Application by INGR Solar (Little Crow) Limited for Little Crow Solar Park
The Examining Authority's written questions and requests for information (ExQ1)
Issued on Tuesday 27 April 2021

ExQ1: Tuesday 27 April 2021

Appendix 6.5  
Detailed landscape proposals  
**LITTLE CROW SOLAR PARK**  
Sheet 1 of 2

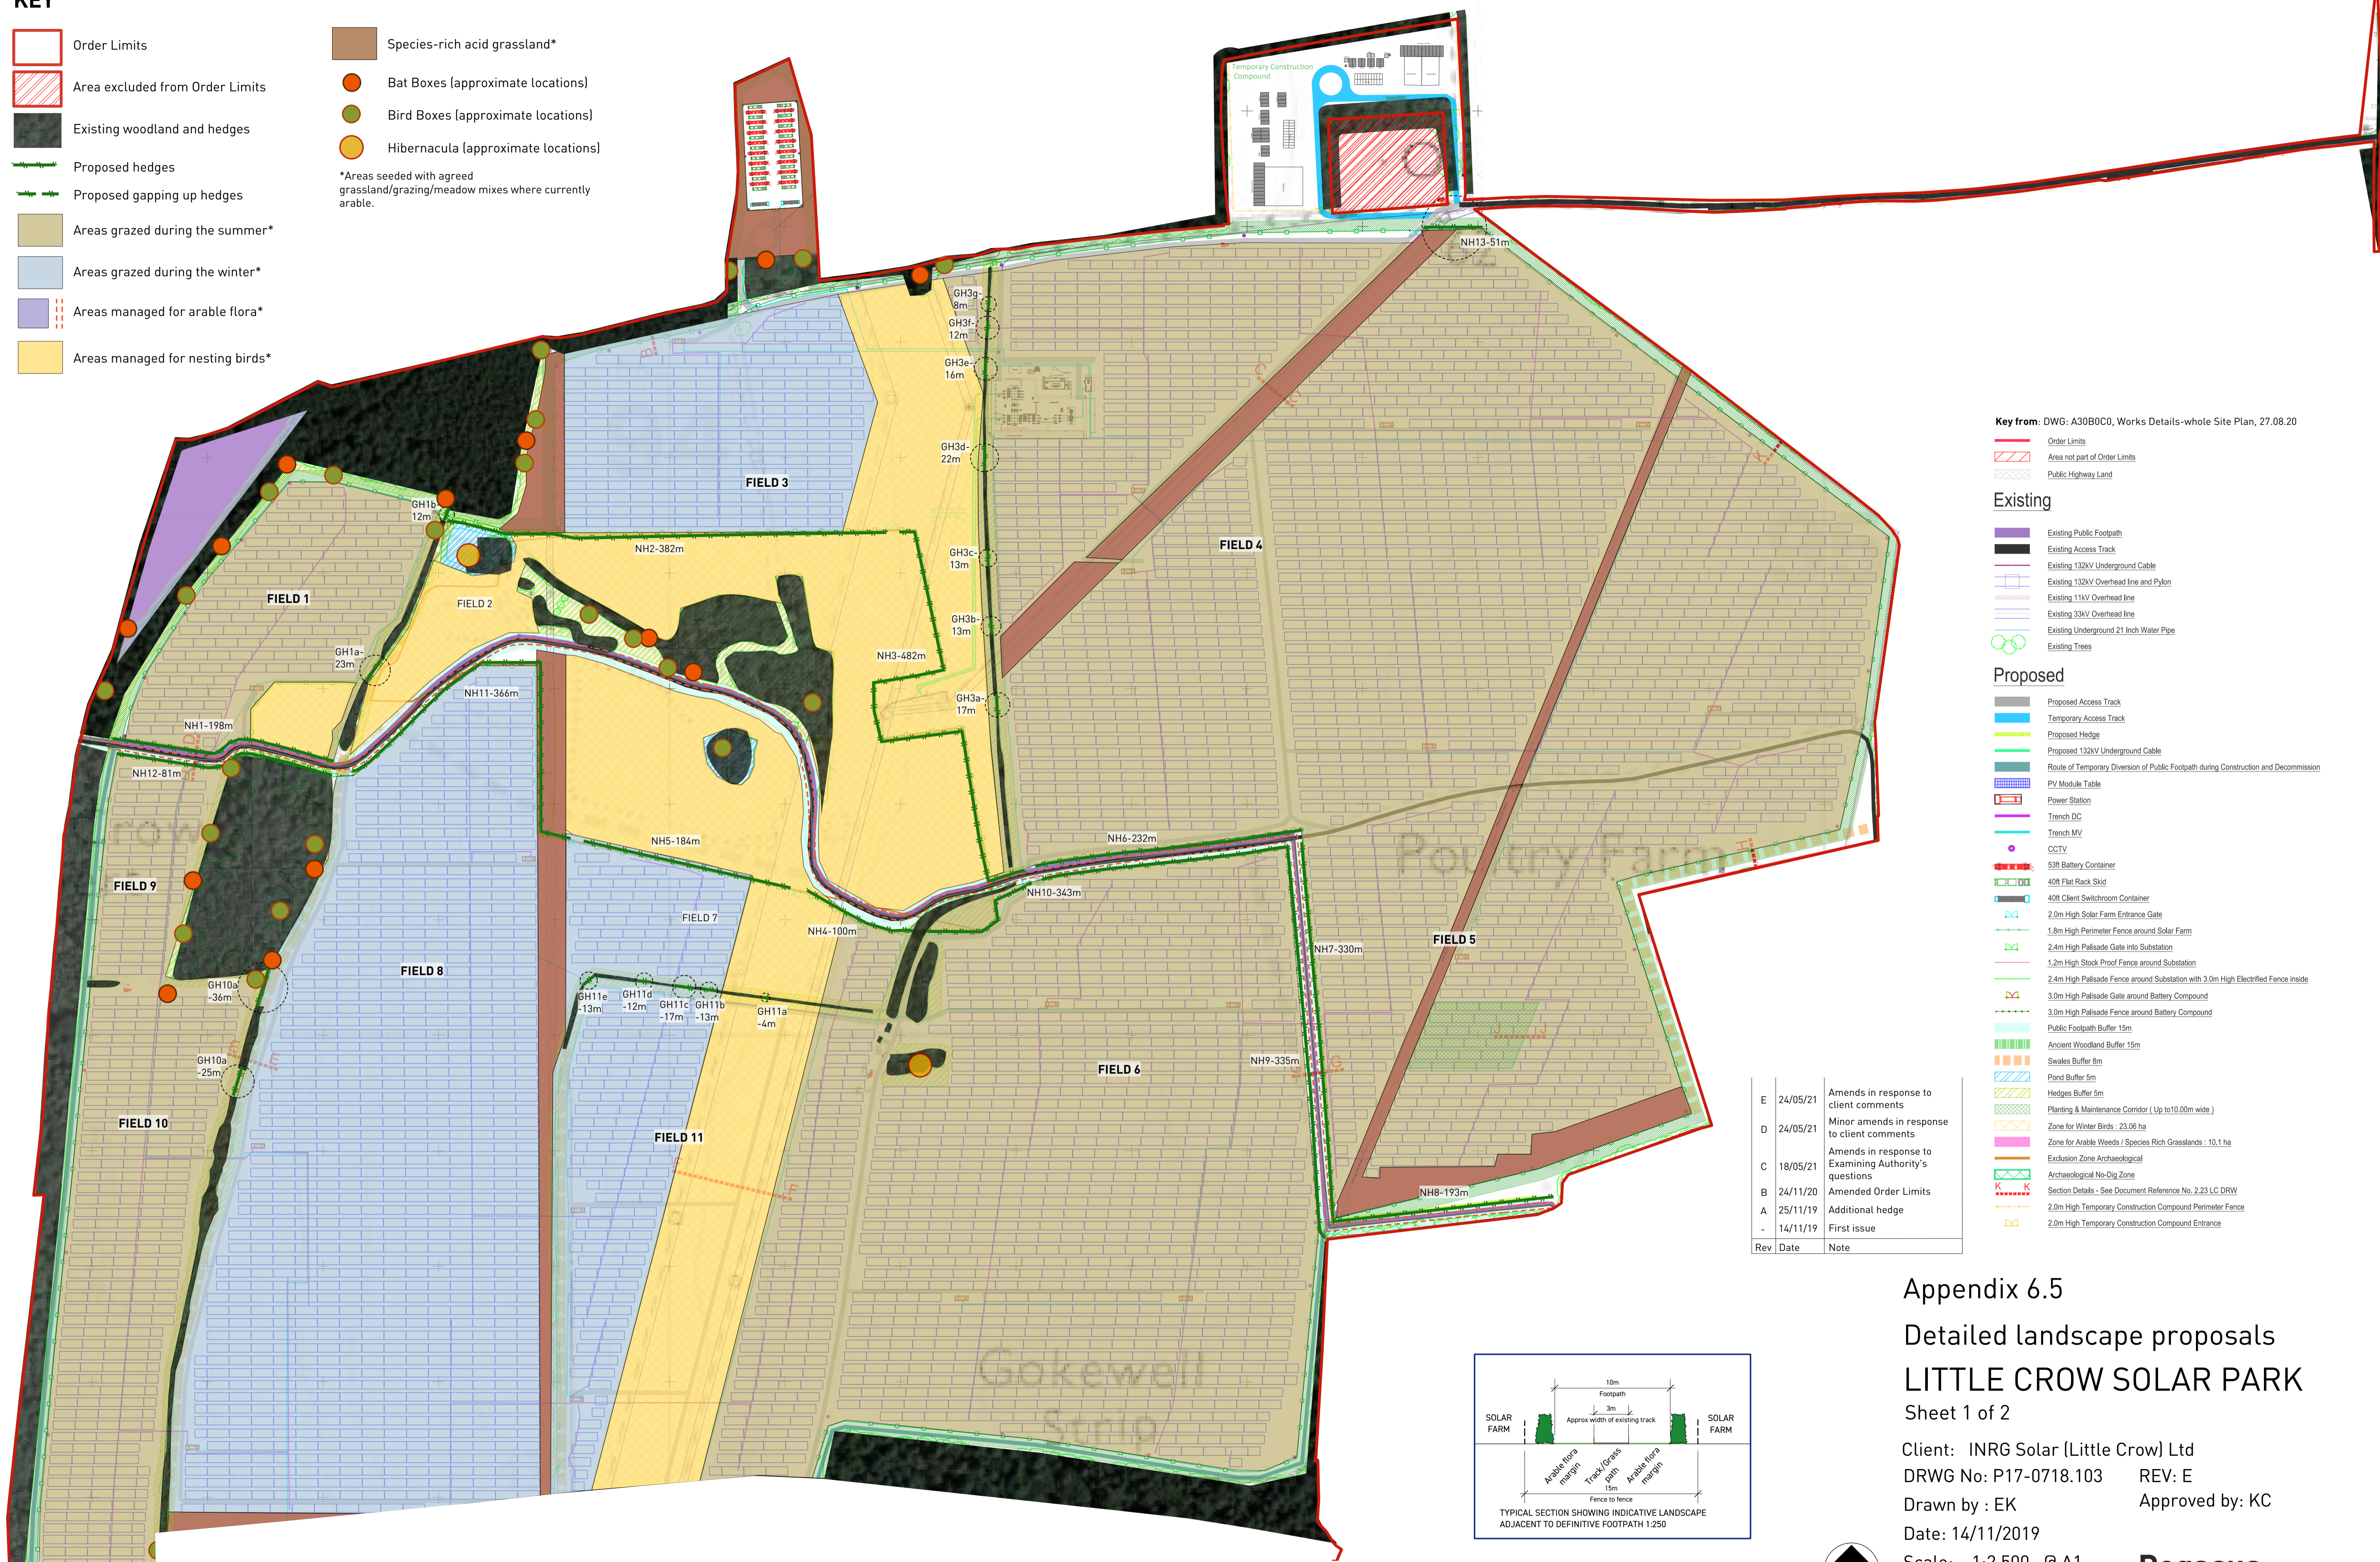
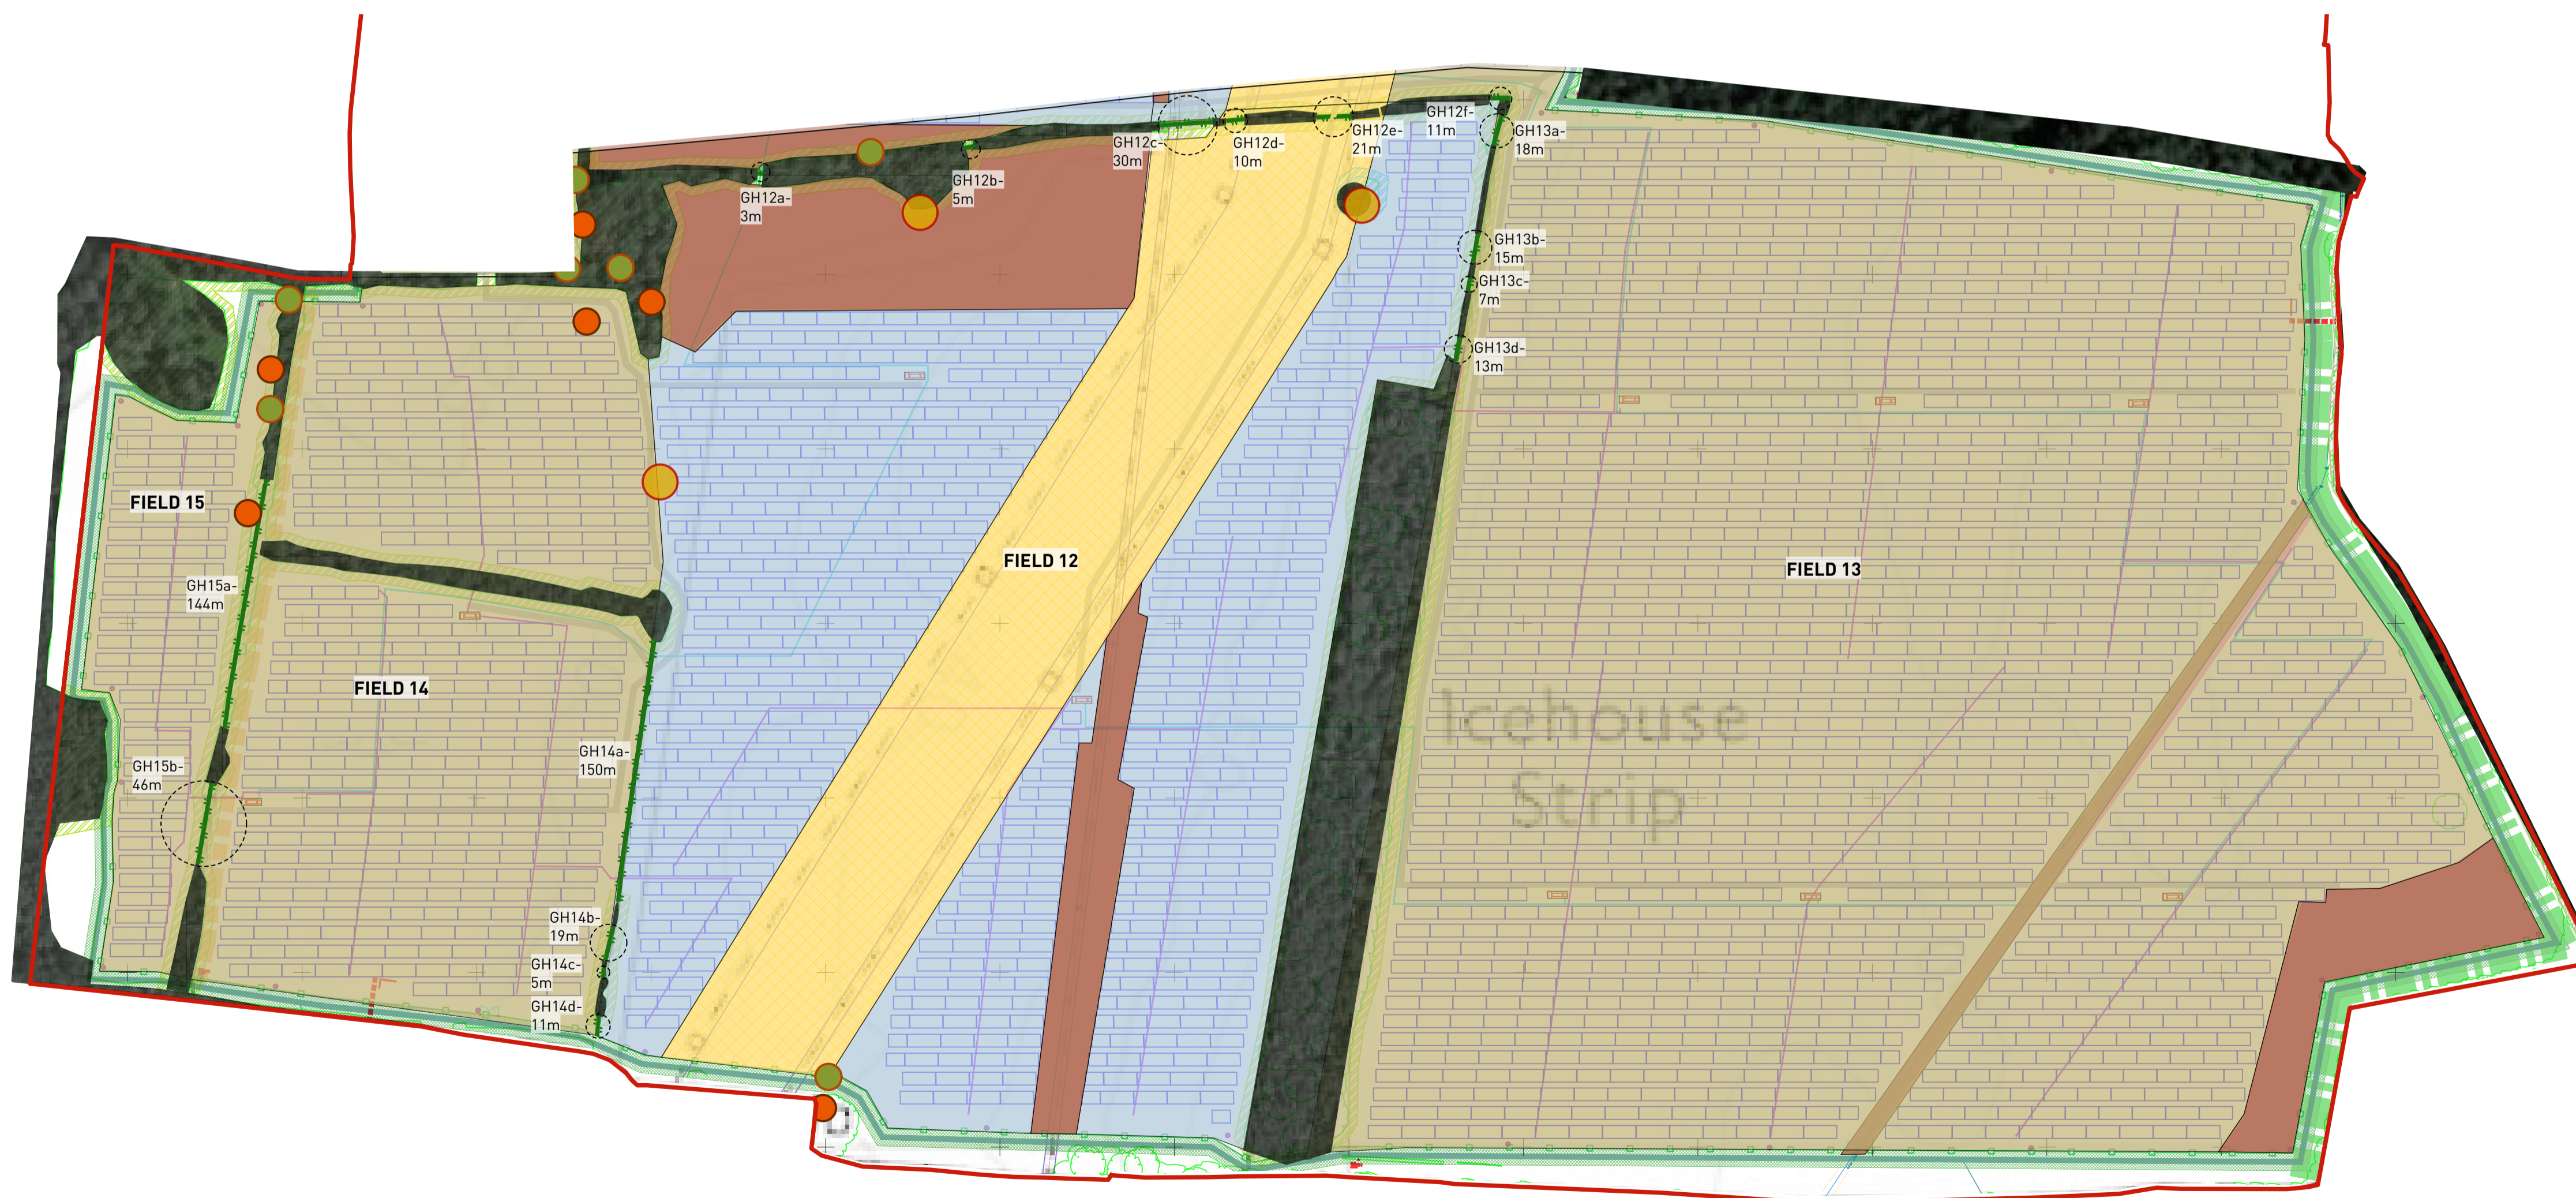
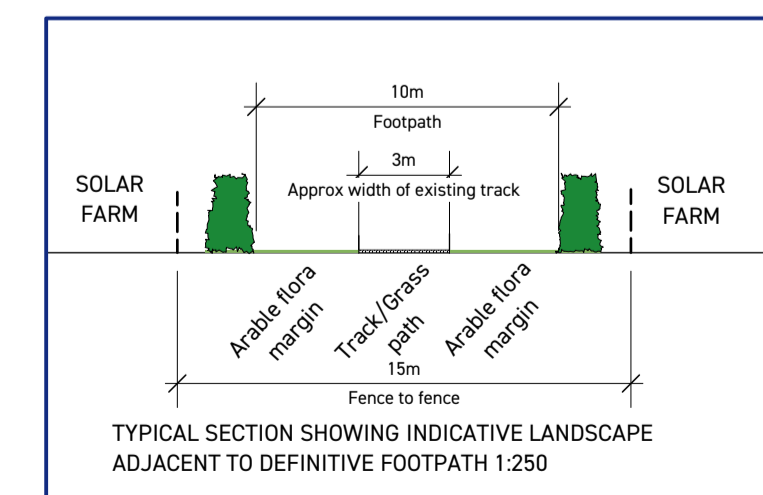
1.8.7	The Applicant	The proposed visual mitigation measures include 'Sowing of wildflower seed along the margins between the footpath and the hedgerows/security fence boundaries' [paragraph 6.5.2 of PDA-006]. Please clarify how it is proposed that mitigation would be secured. Appendix 6.5 'Detailed Landscape Proposals' [APP-090] shows the proposed landscape mitigation, however, wildflower verges are not clearly depicted. Please provide an updated version of Appendix 6.5 showing all the proposed visual mitigation.
